**From:** Kathryn Welch  
**Sent:** 09 August 2021 17:32  
**To:** 'Daniel cooper' [REDACTED]  
**Subject:** RE: F/11/21/PL

**From:** Daniel cooper [REDACTED]  
**Sent:** Tuesday, August 3, 2021 10:27:57 PM  
**To:** Kathryn Welch <[Kathryn.Welch@arun.gov.uk](mailto:Kathryn.Welch@arun.gov.uk)>  
**Subject:** Re: F/11/21/PL

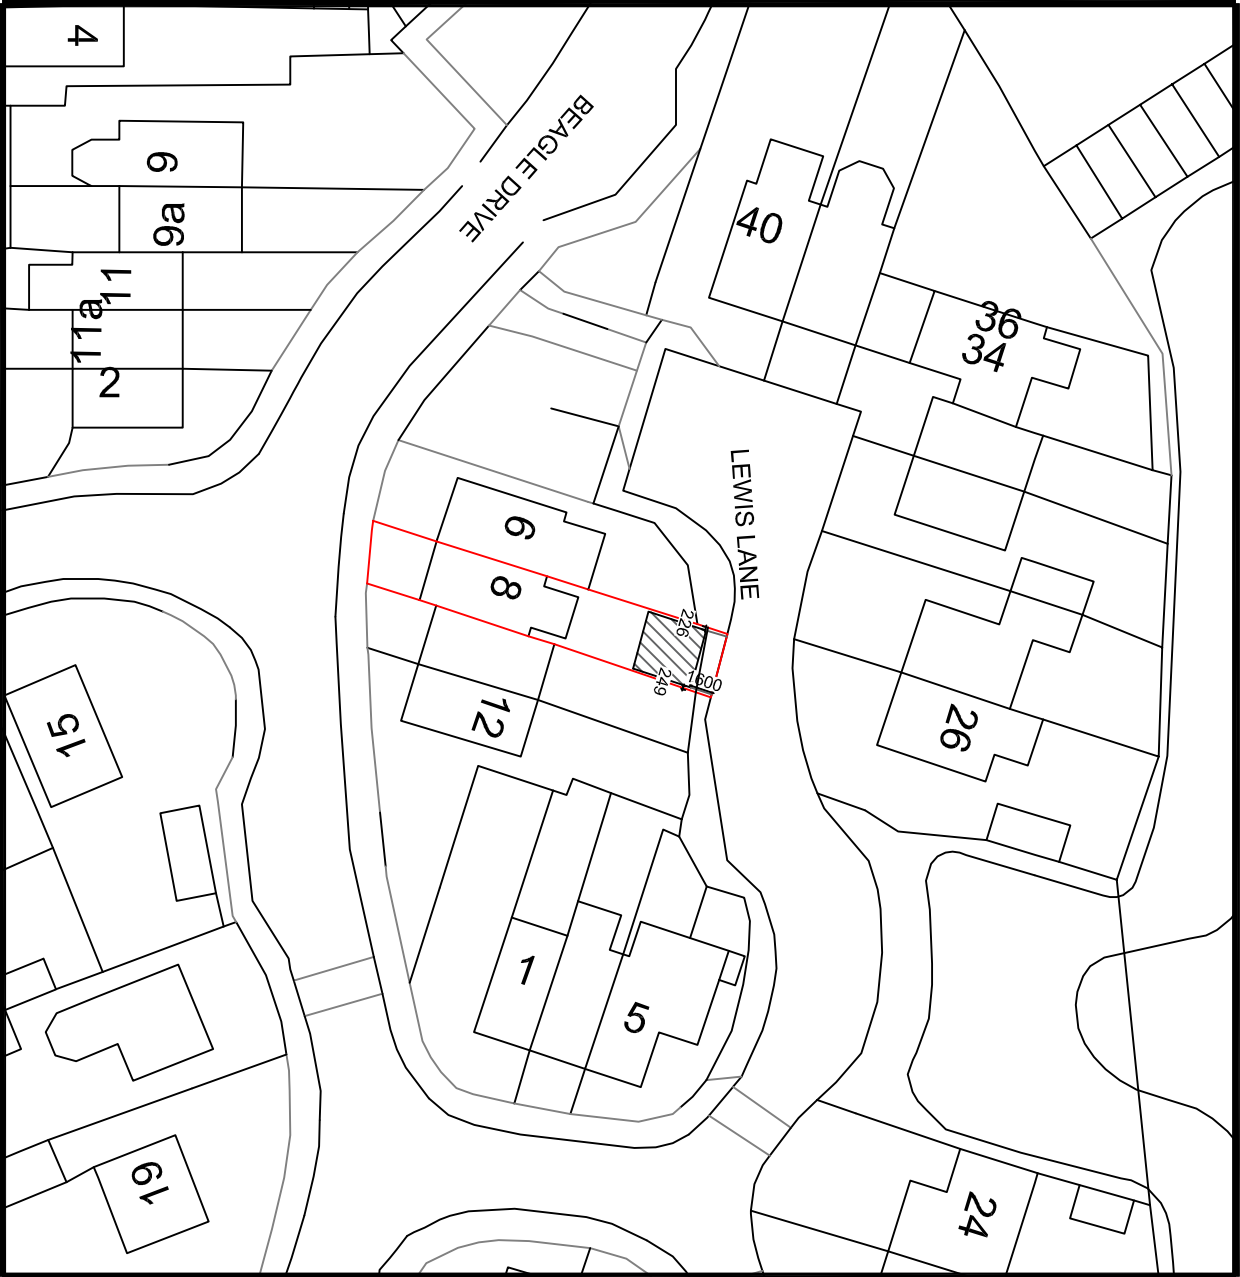
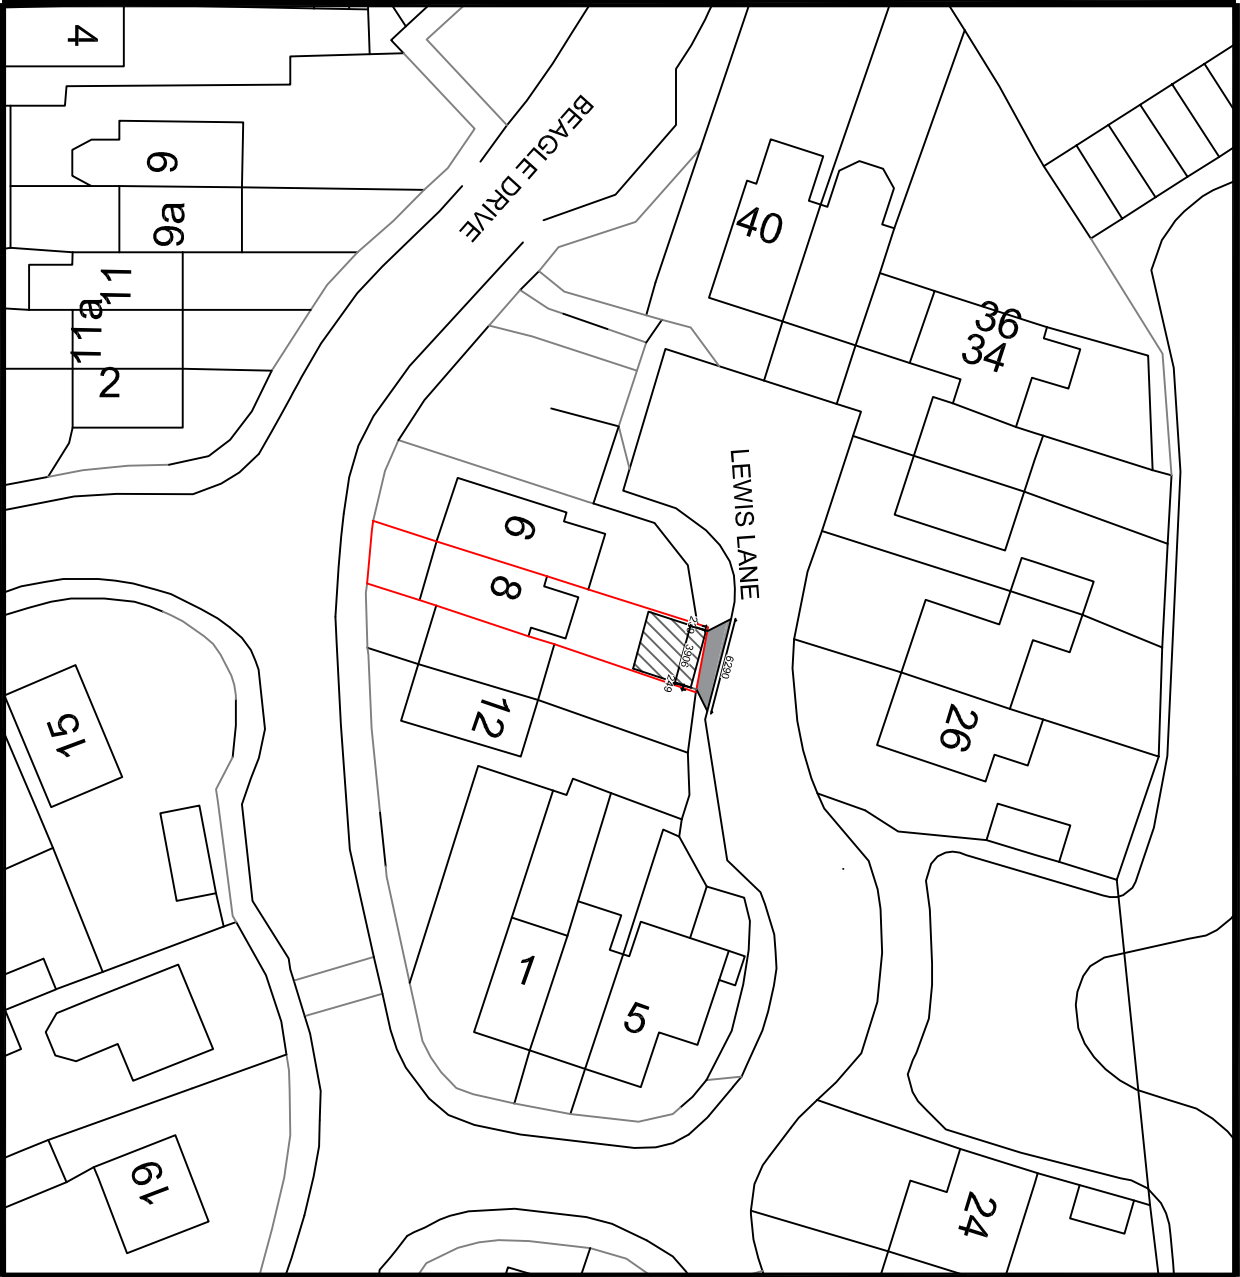
In relation to the highways request. They require a plan showing the existing boundary line with the new boundary line, the google images can be used as supporting evidence but a plan to scale provides the most accurate information and this is needed to determine the size of the strip of land which now forms part of your property. If the garage now forms the boundary this should be annotated to plans.

The advice of the highways is that if a dropped kerb is not intended then the hardstanding will need to be removed. The issue they face is that although you may not wish to use the access for vehicles, future occupants may attempt

to because of the hardstanding provision. So what they are trying to achieve is an all or nothing situation, you either go for the dropped kerb, fully licensed or, its removed and then there is no chance of it ever being used as such. This is a decision you will need to take.
